### AGENDA STAFF REPORT

**ACTION REQUESTED:** Sign the Resolution granting preliminary approval to the Ponderosa Pines Preliminary Plat (P-07-42)

**PRELIMINARY PLAT APPROVAL  
Ponderosa Pines Plat (P-07-42)**

**RESOLUTION**

DRAWN BY: KH	DATE: JUNE 26, 2007	JOB # 07-278 PLAT.dwg COMP 01-504-5.crd KB
CHECKED BY: J. BENTLEY	SCALE: 1" = 200'	SHEET 1 OF 2

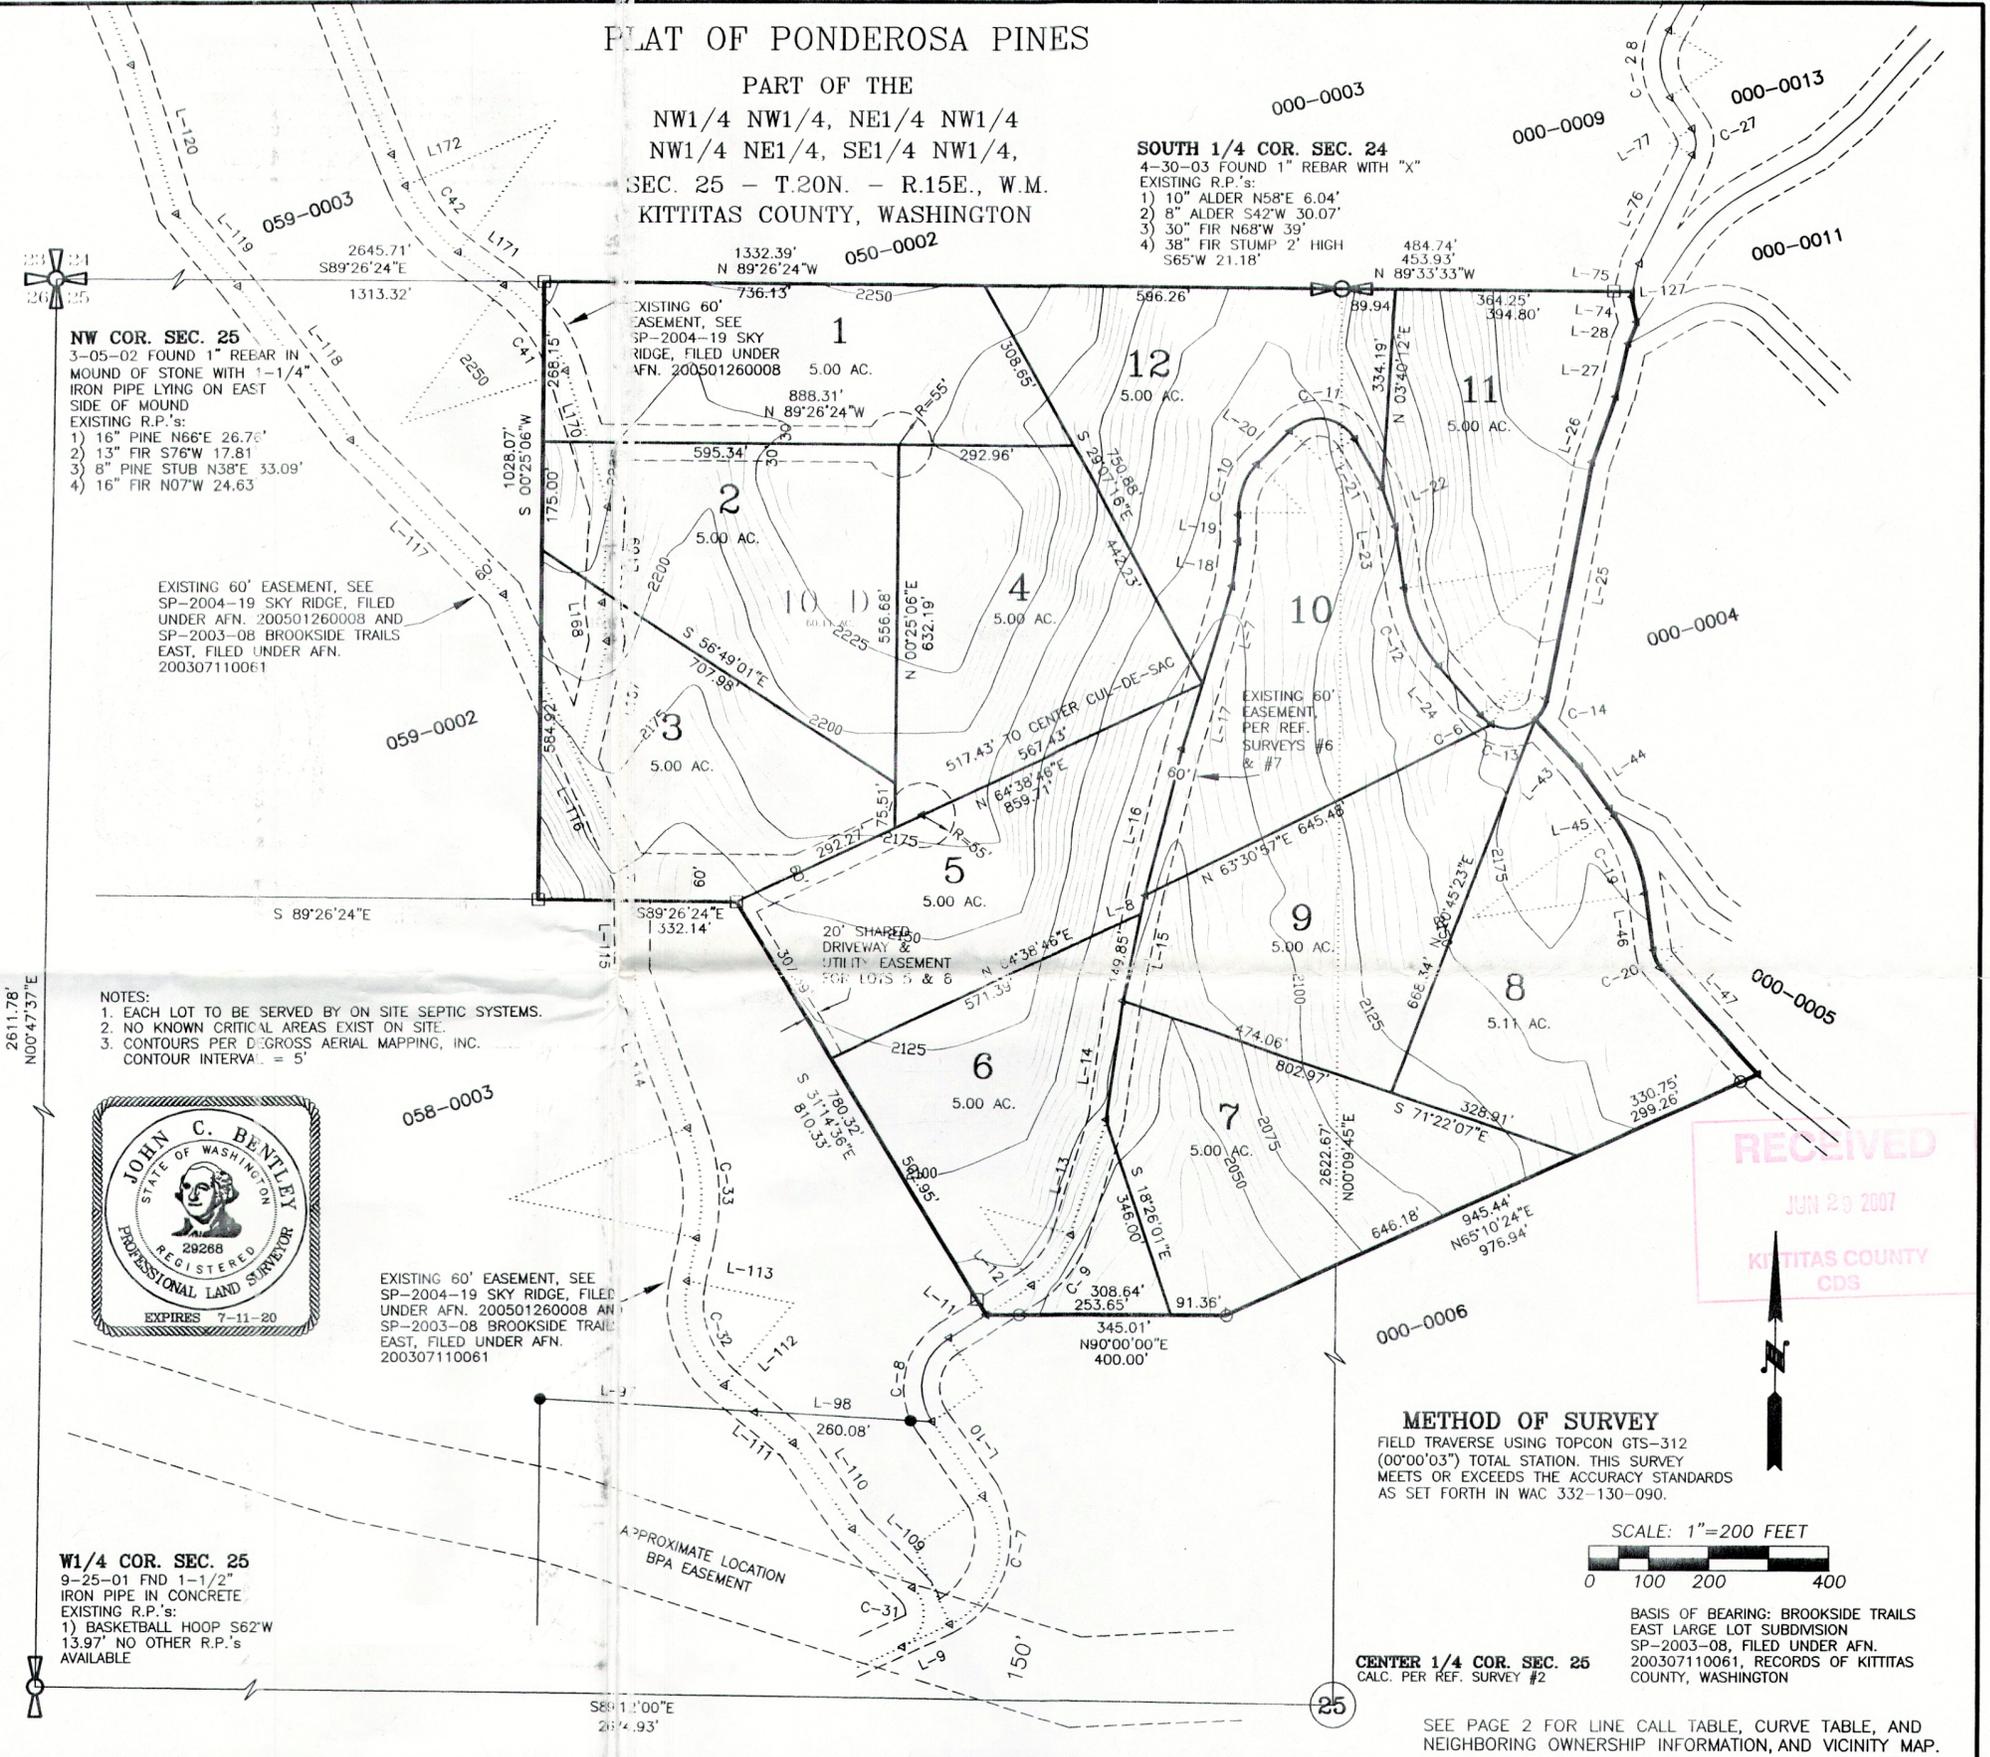
8. Second Access: A second access is required of this development and has been identified as a road leading from Jack Pine Drive to Big Tail Road to Deer Creek Road to Cle Elum's Montgomery Avenue. The second access shall be constructed to meet or exceed the conditions of a Low-Density Private Road. If the access will be emergency use only, the gate must be approved by the Fire Marshal.

9. Private Road Improvements: Access from Columbia Avenue to the final access points on Jack Pine Drive, Creekside Road, and Owl Ridge Drive, and the second access from Jack Pine Drive to Montgomery Avenue shall be constructed to meet or exceed the conditions of a Low-Density Private Road. See Kittitas County Road Standards, 9/6/05 edition.

10. Cul-de-Sac: A turnaround is required on Creekside Road. The applicant has the option to either build a turnaround near the intersection of Creekside and Owl Ridge Roads, or to certify Creekside Road from Columbia Avenue to an existing offsite cul-de-sac. If the second option is chosen, the easement up to the cul-de-sac must be shown on the face of the plat.

- a. Access easements shall be a minimum of 60' wide. The roadway shall have a minimum width of 20', with 1' shoulders, for a total width of 22'.
  - b. Minimum centerline radius shall be 60'.

- c. The surface requirement is for a minimum gravel surface depth of 6".
  - d. Maximum grade is 12%.
  - e. Stopping site distance, reference AASHTO.
